Fwd: MMC CMP and detours- to PB Workshop on 2/27

From: **James Sweatt** <jjs@portlandmaine.gov>
Date: Fri, Feb 23, 2018 at 9:50 AM
Subject: Re: MMC CMP and detours- to PB Workshop on 2/27
To: Jean Fraser <jf@portlandmaine.gov>
Cc: "O'Brien, Stuart" <sgo@portlandmaine.gov>, "Barhydt, Barbara" <bab@portlandmaine.gov>

[ Visitors Garage ] Logistics Plans and Studies

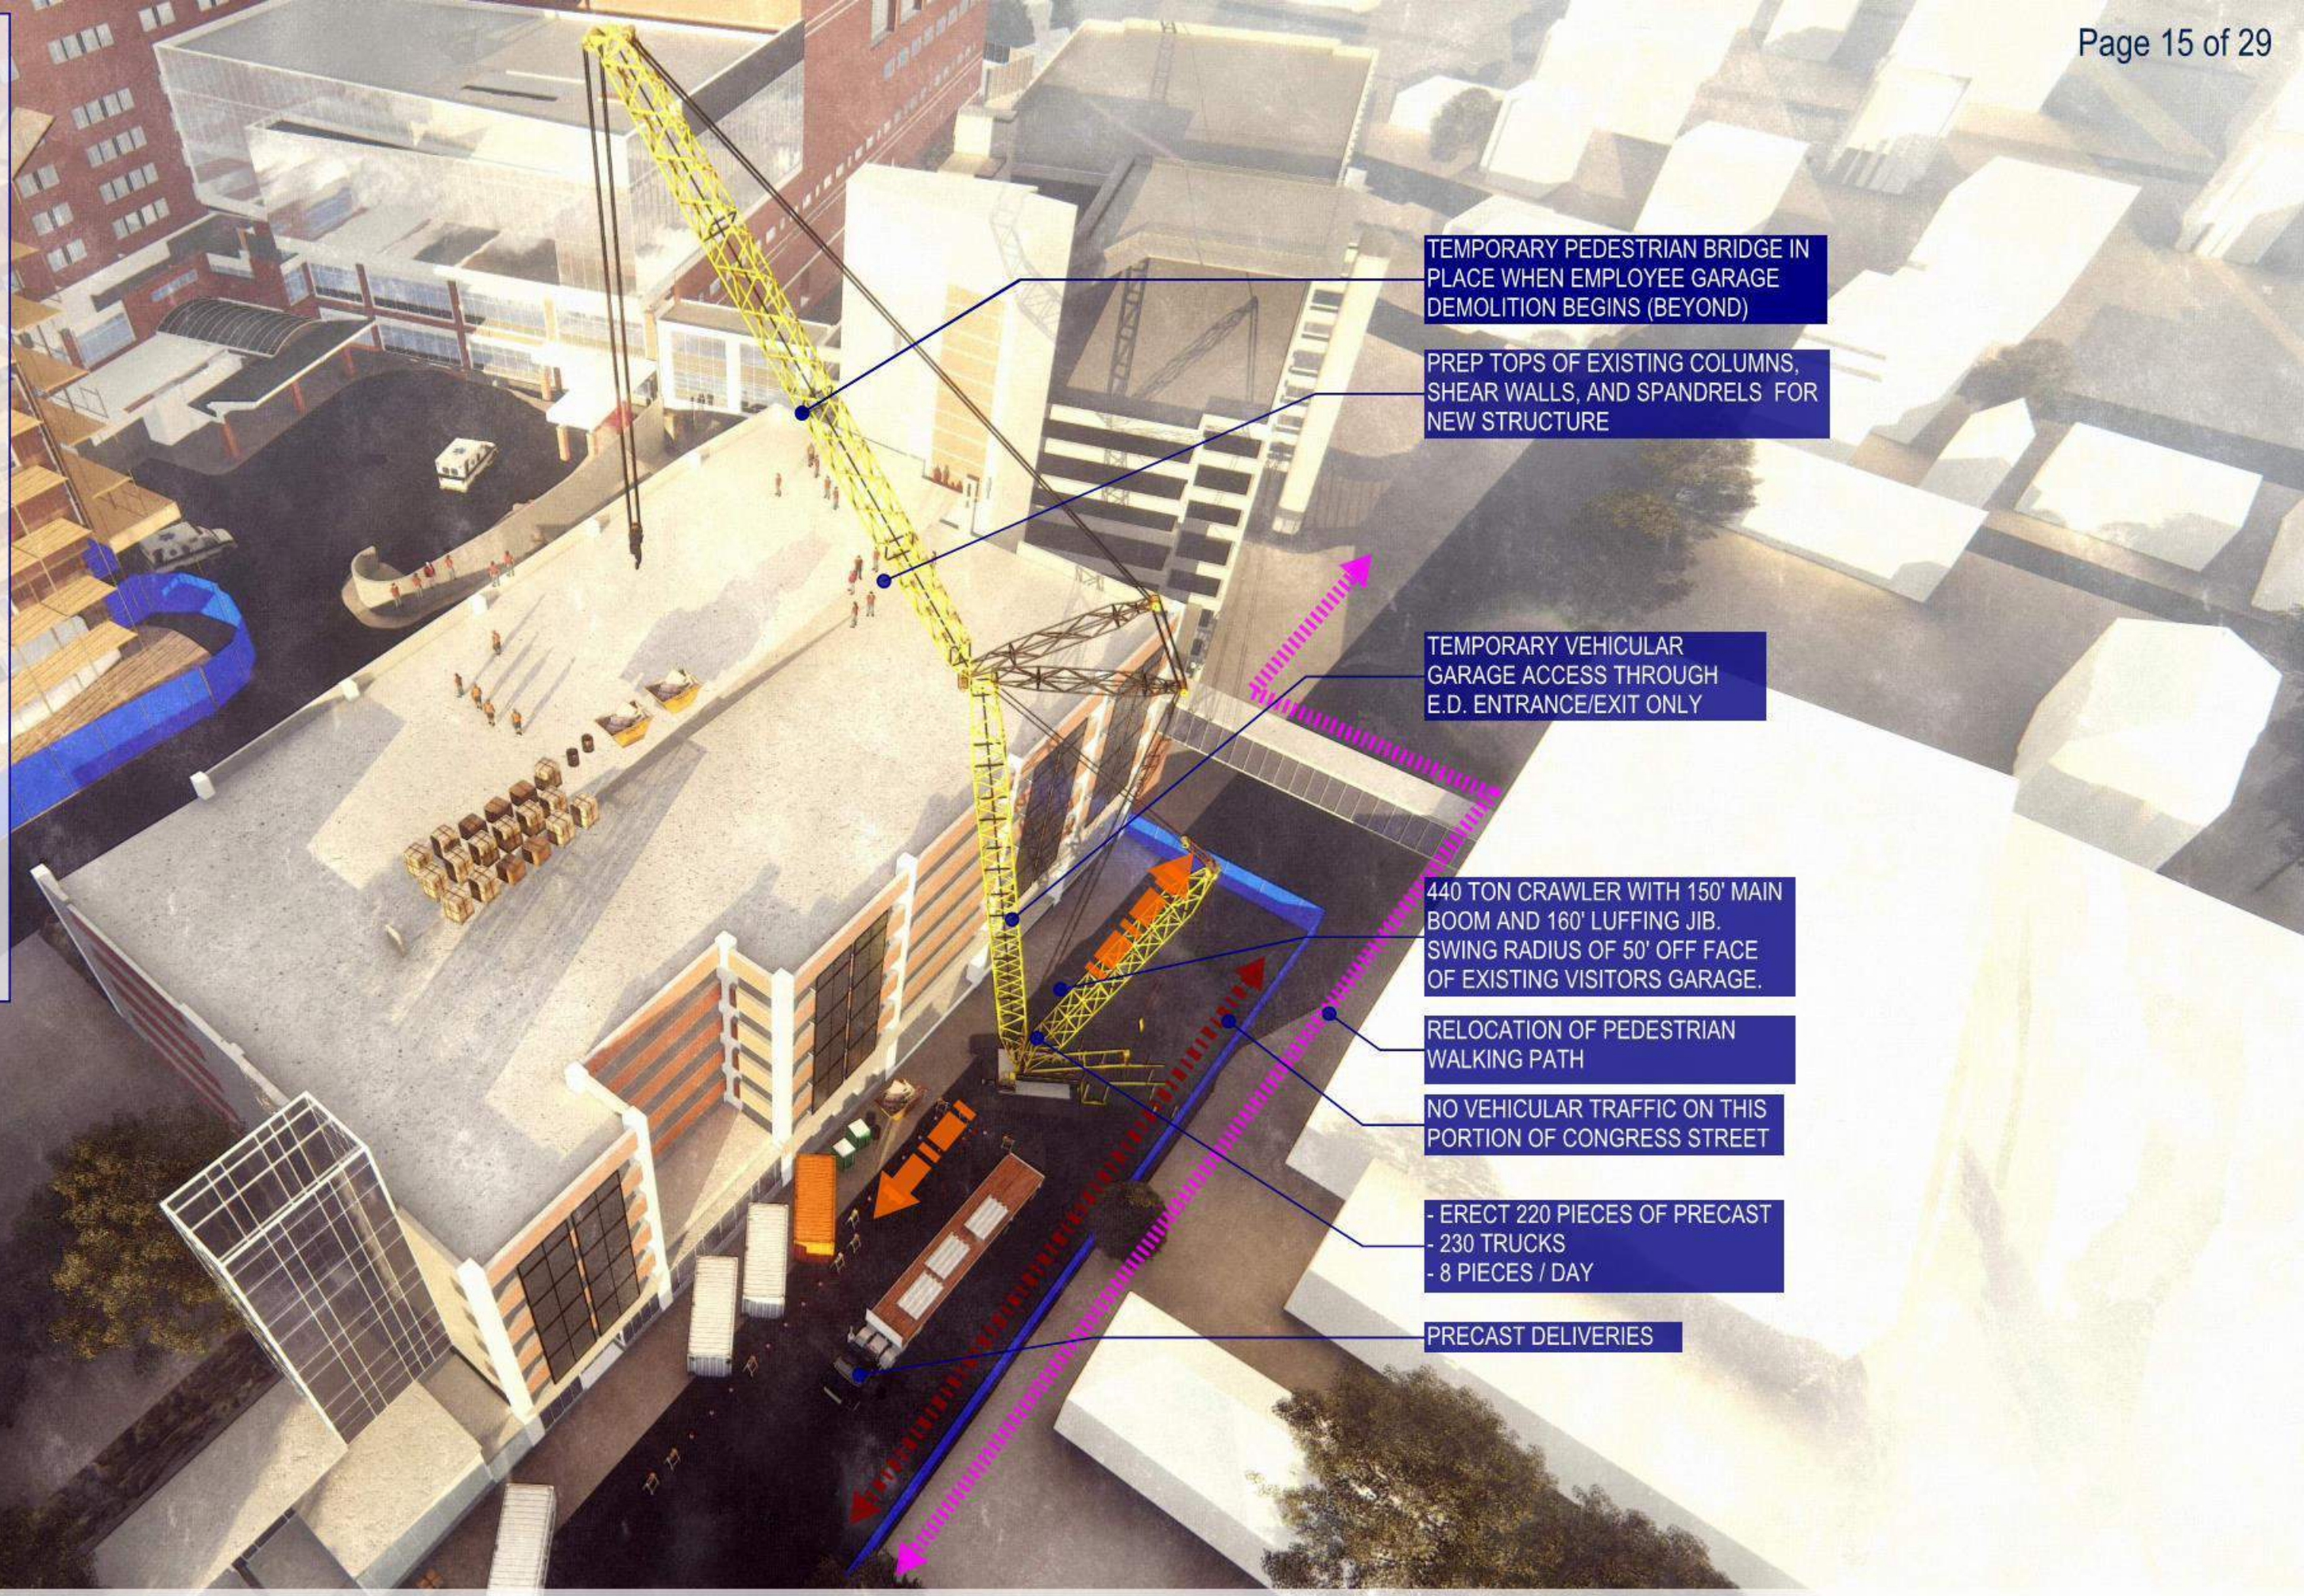
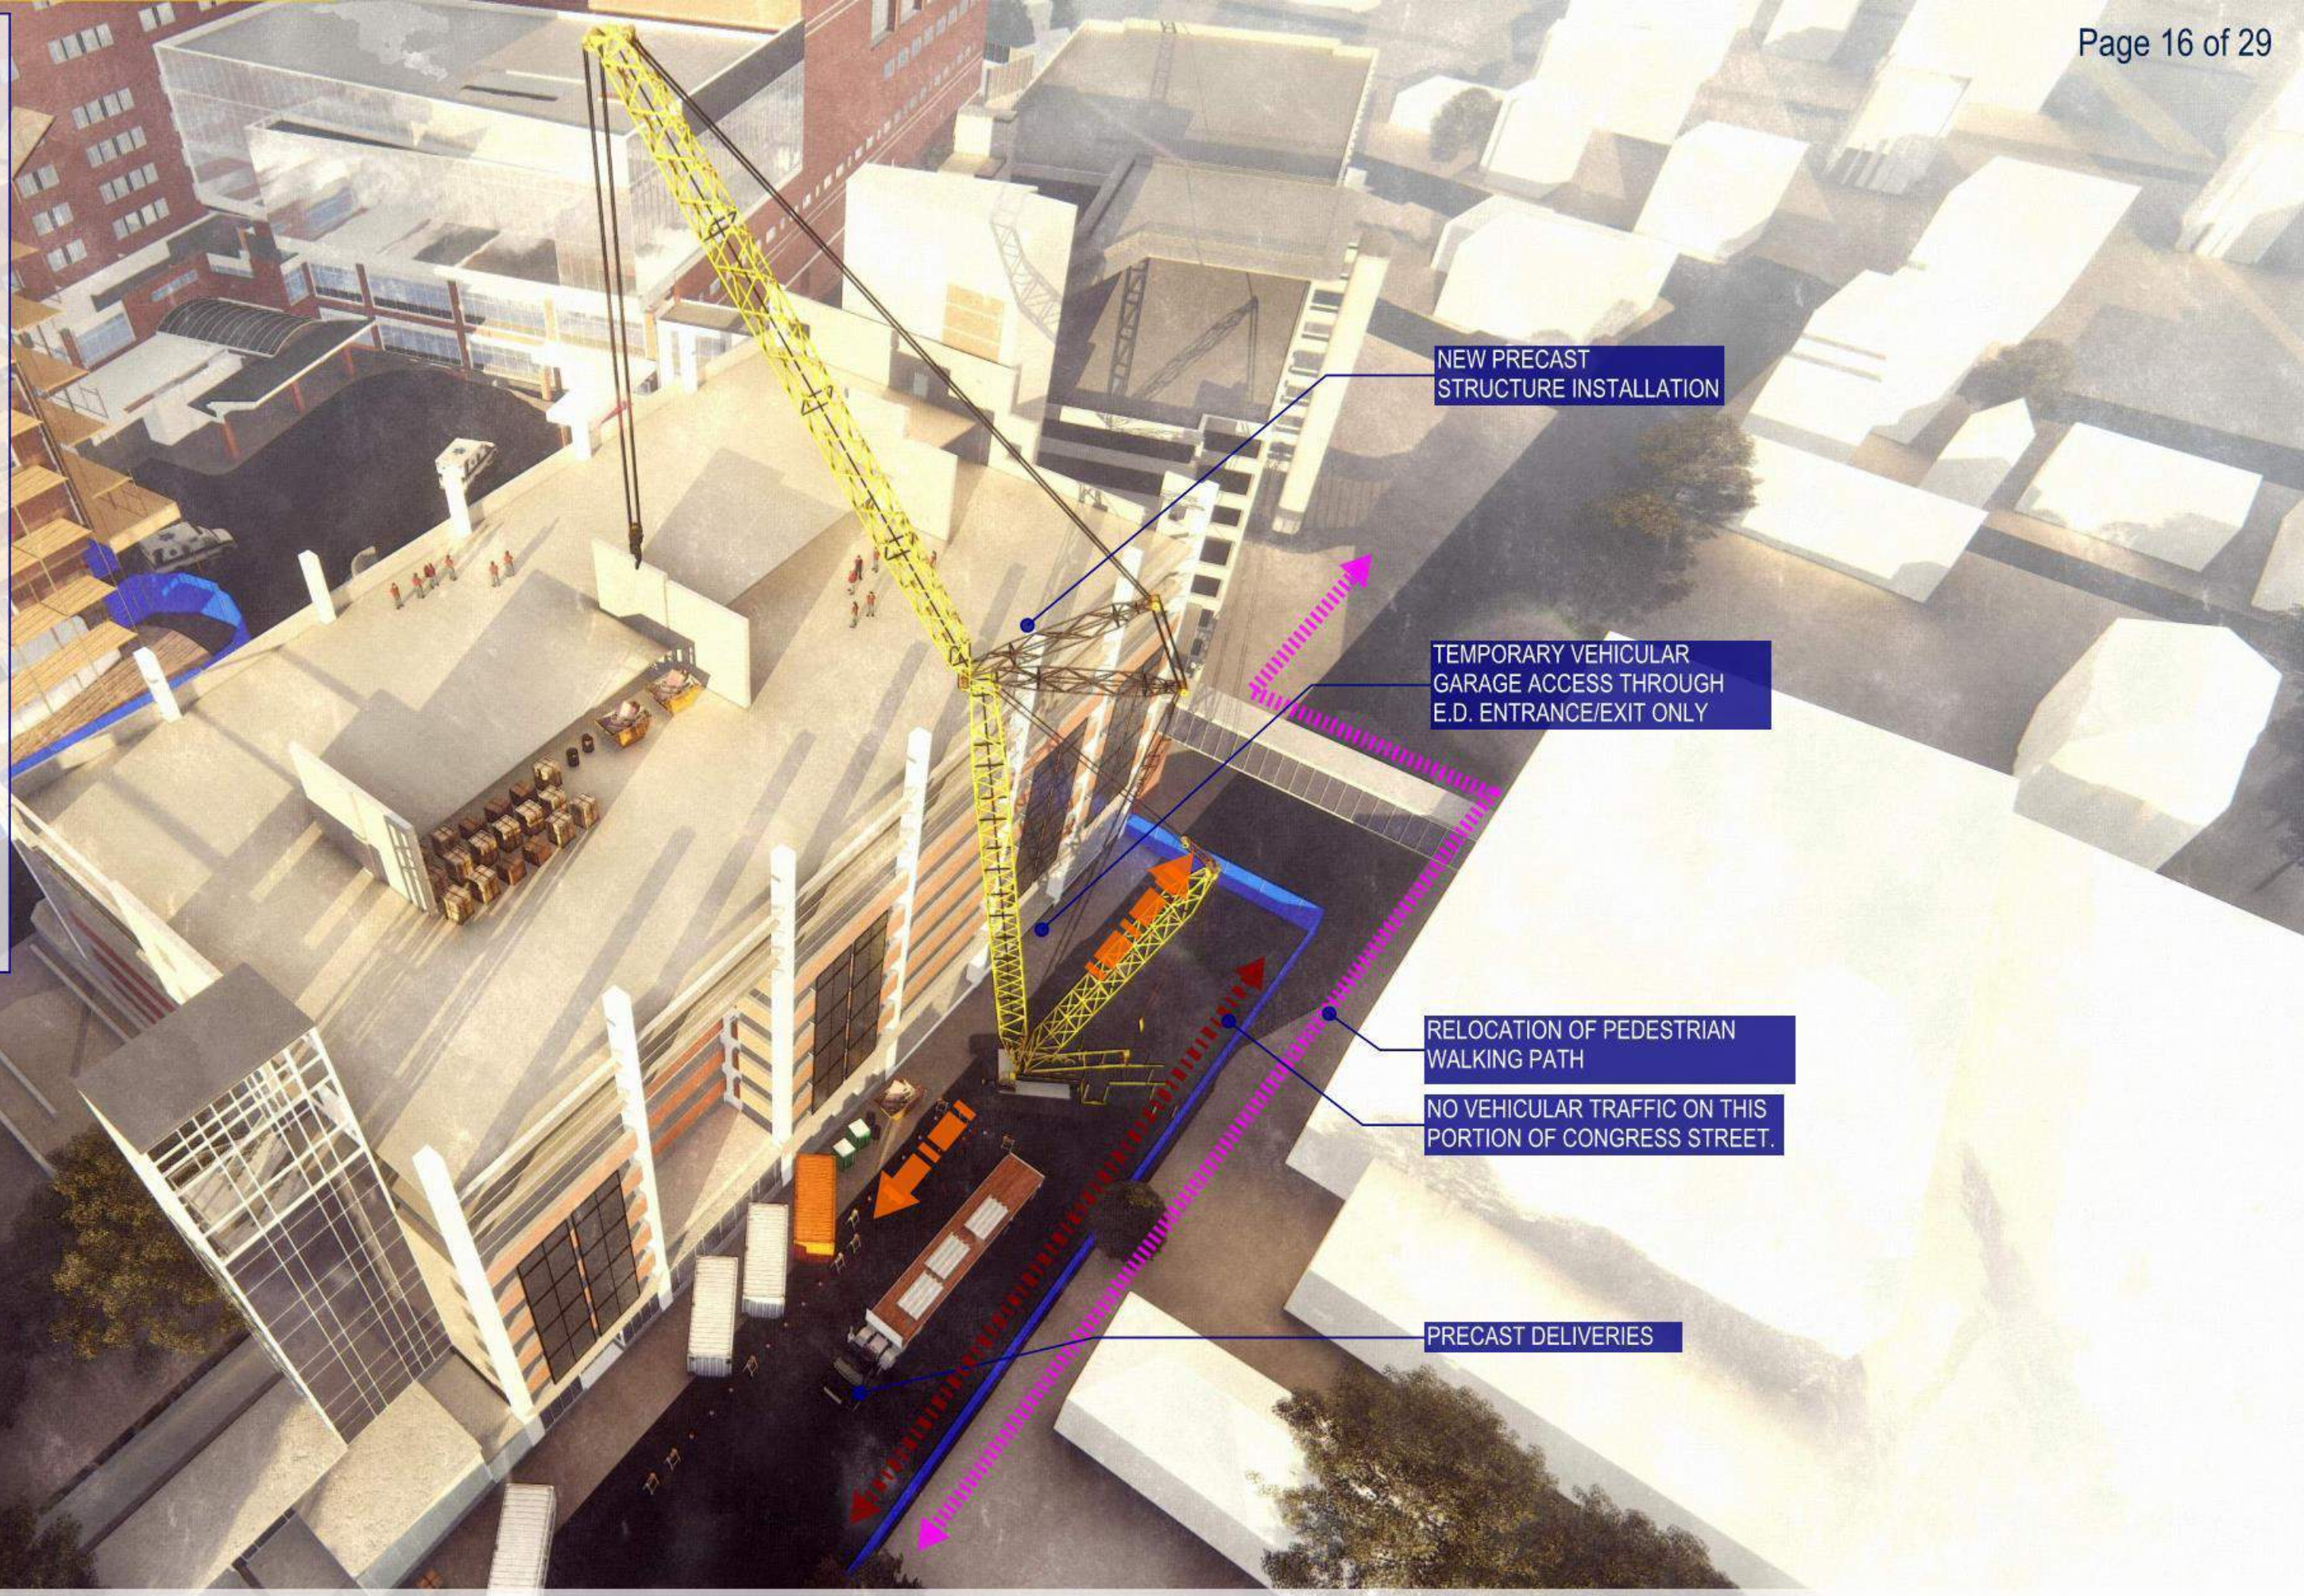
We have read, and was present during Kleinfelder's presentation of the engineering data and crane placement recommendations. It appears it will be necessary to close Congress St for the 8 week period that Turner construction has projected. It will be imperative that Turner keep to this schedule and we would recommend incentives to open Congress St sooner and substantive penalties for delays beyond 8 weeks. It will be crucial that the closure of Congress Street not extend past June 29th to avoid conflict with the highest summer traffic flow.

Turner construction must also manage the delivery of concrete casts to Congress St and steel to East Tower in a manner to avoid large vehicles with heavy loads moving during morning commuter hours (0700-1000) and afternoon hours (1500-1800). We continue to recommend the delivery and staging of large vehicles before and after normal commuting hours to reduce the impact on traffic and pedestrians.
